Response to Submissions – Cooranbong Stockpile Extension Centennial Coal Company Ltd

Prepared for: **Ron Bush** – General Manager Development & Approvals-
Centennial Coal Company Ltd
M: 0436 034 401
E: Ron.Bush@centennialcoal.com.au

Date: **04 May 2026**

Project no: **ER092**

www.ghd.com
scale
1:2000 for A3
project no.
12653109

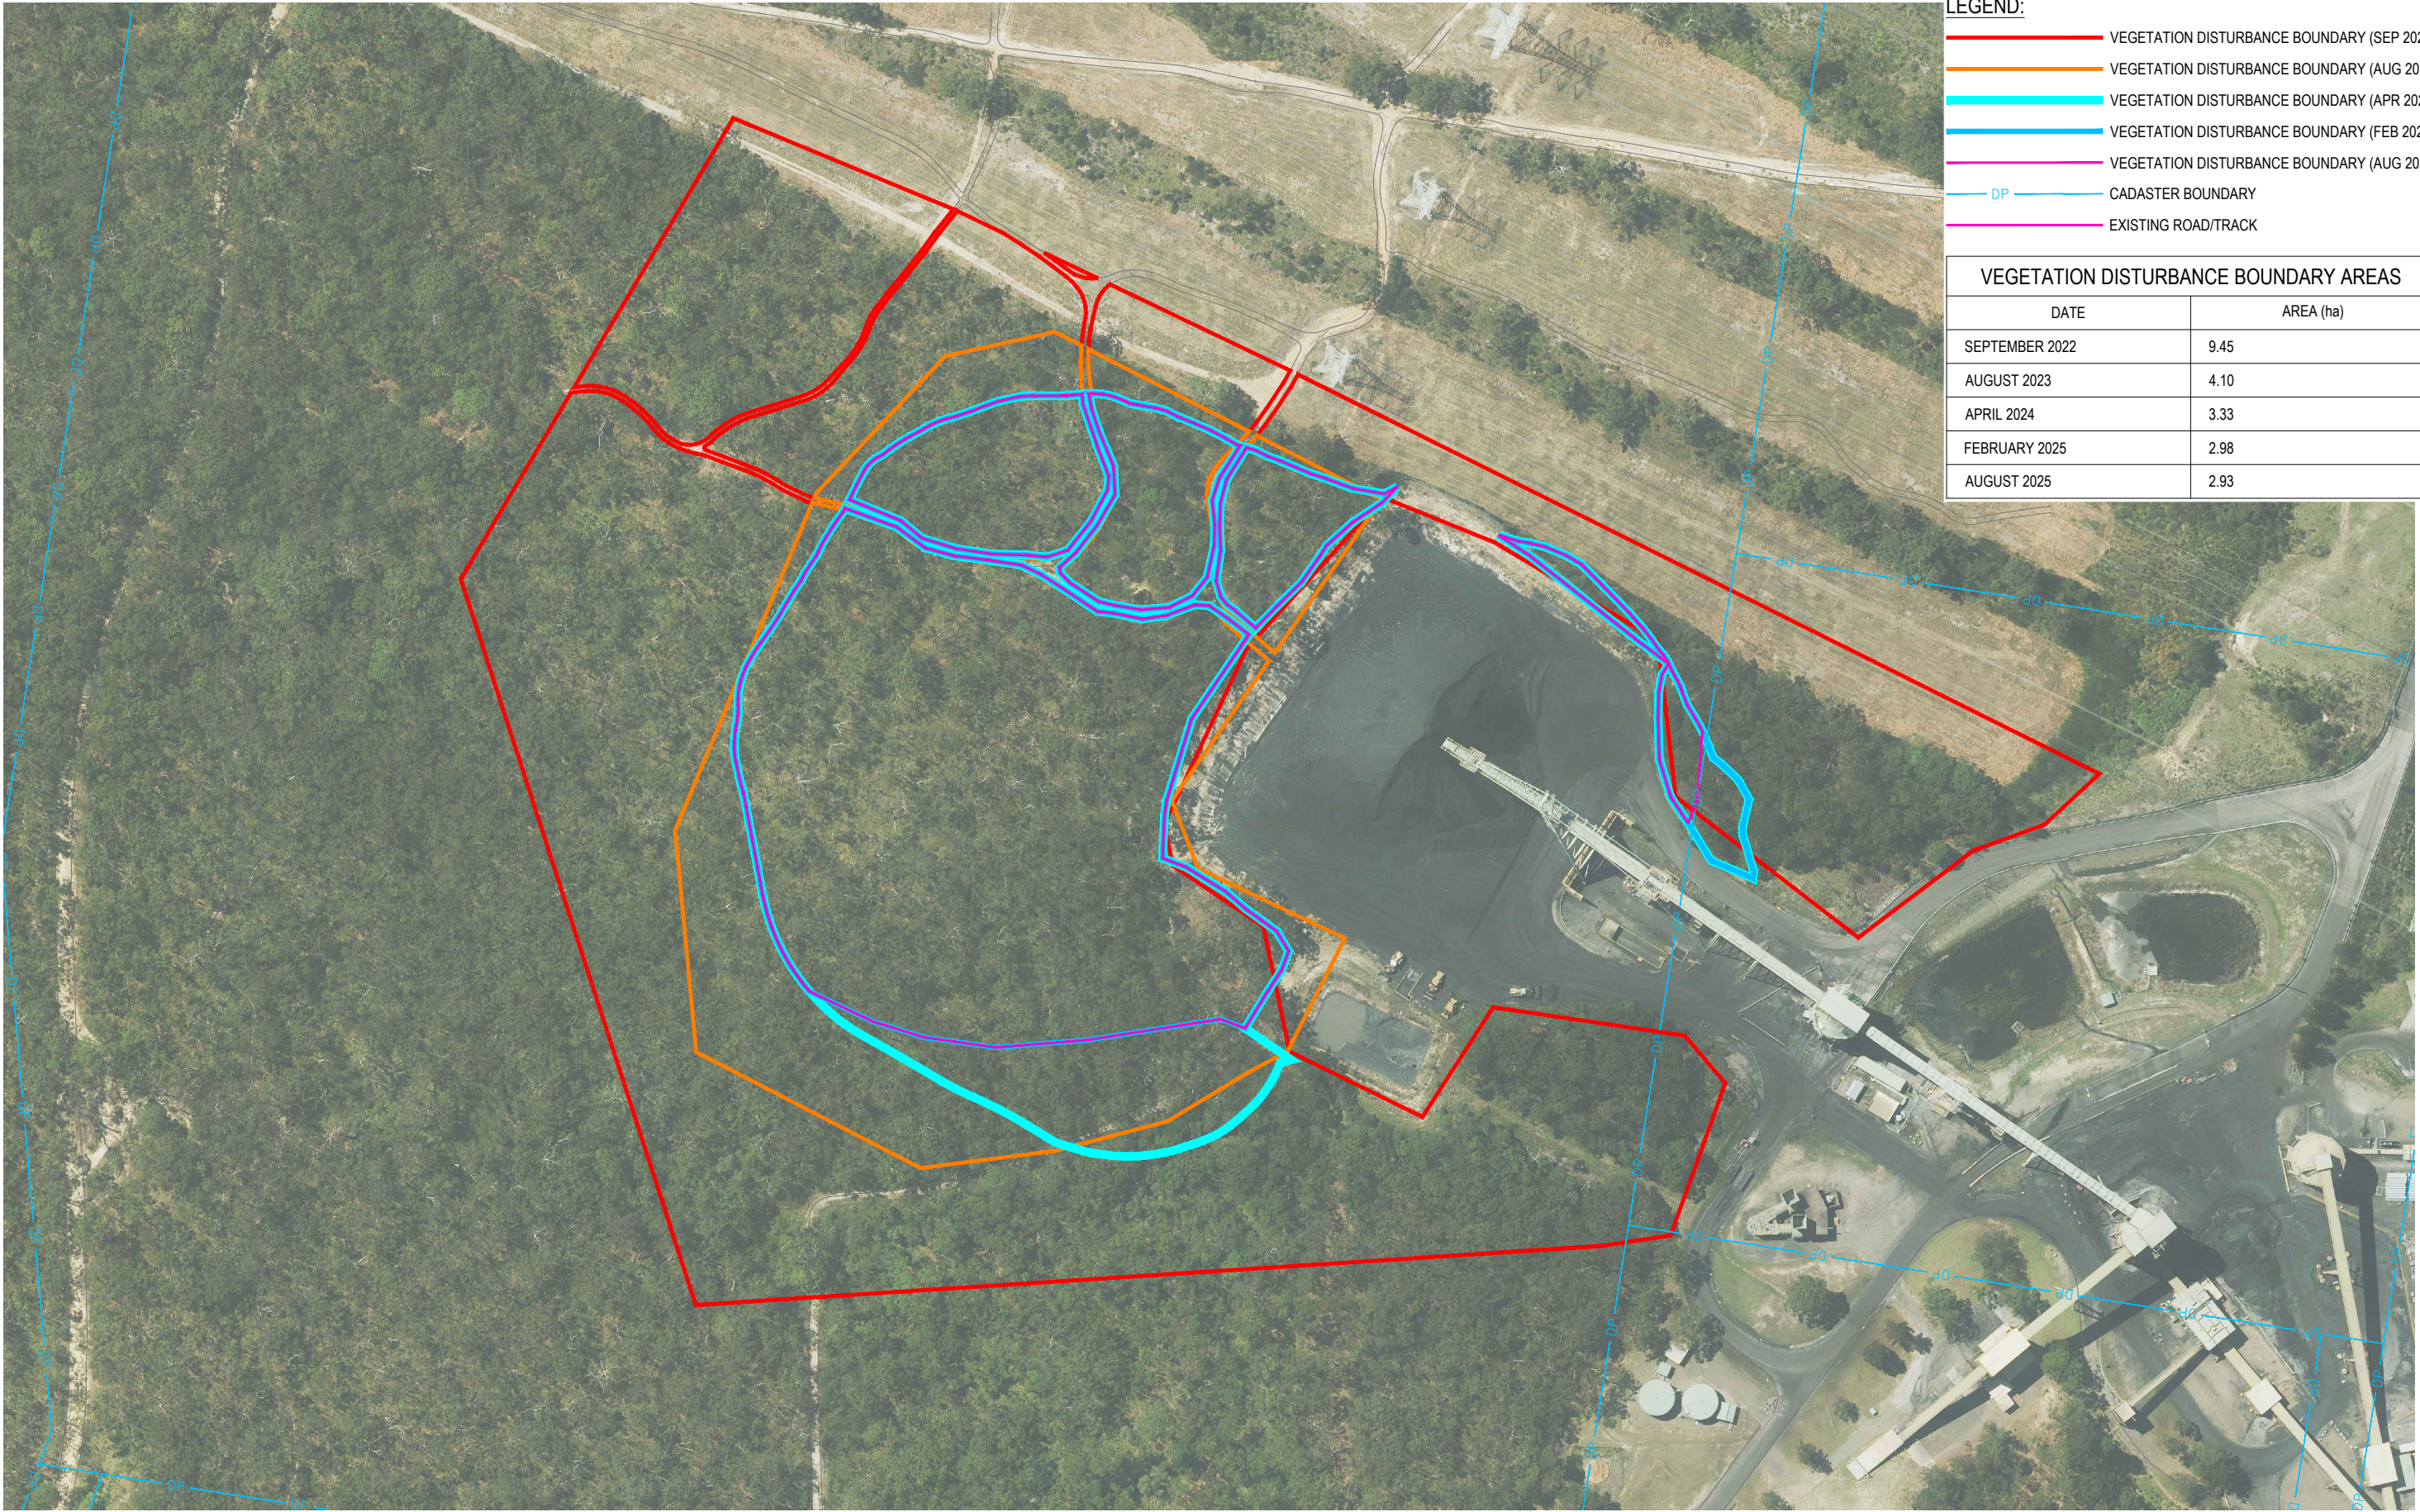
2. Inadequate avoidance and minimisation of Biodiversity issues The BDAR does not adequately address the avoid, minimise and offset hierarchy as per section 6.3A of the Biodiversity Conservation Act 2016 (BC Act). The BDAR does not identify how the significant findings of the Stage 1 BAM Assessment have informed the avoid and minimise strategy and led to impacts to biodiversity being avoided. The assessor should document the analysis and evolution of the avoid and minimise options in the BDAR (see Section 3.3 of the BAM (2020) Stage 2) to provide transparency and support decision making. The assessor needs to demonstrate how reasonable avoid and minimise measures have been genuinely and robustly explored, including an evaluation of feasible alternatives, spatial identification of areas avoided, and supporting analyses, data, and justifications for the decisions made. The BDAR lacks any substantive analysis or documentation addressing how impacts have been avoided or minimised in accordance with the BAM. Given the significant impacts to threatened species and threatened species habitat, it is strongly recommended that alternative technologies, processing methodologies, and alternative areas are explored for the stockpile expansion. A refinement in disturbance area is mentioned in the BDAR but this should be further discussed, documented and clearly mapped, as part of Stage 2 of the BAM, demonstrating that alternate locations, technologies or processing methodologies have been considered. The BDAR also needs to document how the findings of Stage 1 BAM Assessment have informed the avoid and minimise strategy. CPHR requests further avoidance of impacts to: - Threatened species (<i>Grevillea parviflora</i> subsp. <i>parviflora</i> and <i>Tetratheca juncea</i>) - Habitat features such as hollow bearing trees used by Squirrel Gliders and possibly Masked Owls and Glossy Black-Cockatoo’s. Loss of hollow bearing trees is a key threatening process. CPHR considers the loss of this high value threatened species habitat to be unacceptable given the rates of habitat loss and extinction in NSW, and the inadequate avoid and minimise strategy presented in the BDAR.	Recommended action: - CPHR recommends that alternate locations, technologies or processing methodologies are considered and genuinely explored in the BDAR to avoid impacting this area of high biodiversity value. - CPHR recommends further avoidance, with demonstration of how biodiversity constraints have informed design of the proposal. - The assessor is required to clearly present evidence of avoiding or minimising impacts on biodiversity values in accordance with Chapter 3 of Biodiversity Assessment Method 2020 Operational Manual – Stage 2. - CPHR recommends refinement of project footprint, to avoid high value biodiversity (i.e. large hollow bearing tree (HBT)s) and thereby updates to the BDAR, BAM-C and spatial package are required as appropriate.	S-BDAR	EcoResolve			We appreciate that the proposed modification has impacts to threatened species and their habitats. As described in Section 5.1, the subject land has been reduced substantially through two revisions, reducing loss of native vegetation from ~9.5 ha down to ~2.93 ha. Direct impacts to aquatic habitat have been eliminated from the proposal as well. While 2.93 ha of woodland will still be directly impacted, further reductions to the footprint of the proposed modification would negatively affect the planned future operational capabilities of the CES. We believe that a reasonable compromise has been reached between the avoidance and minimisation of direct impacts and the operational needs of the CES.
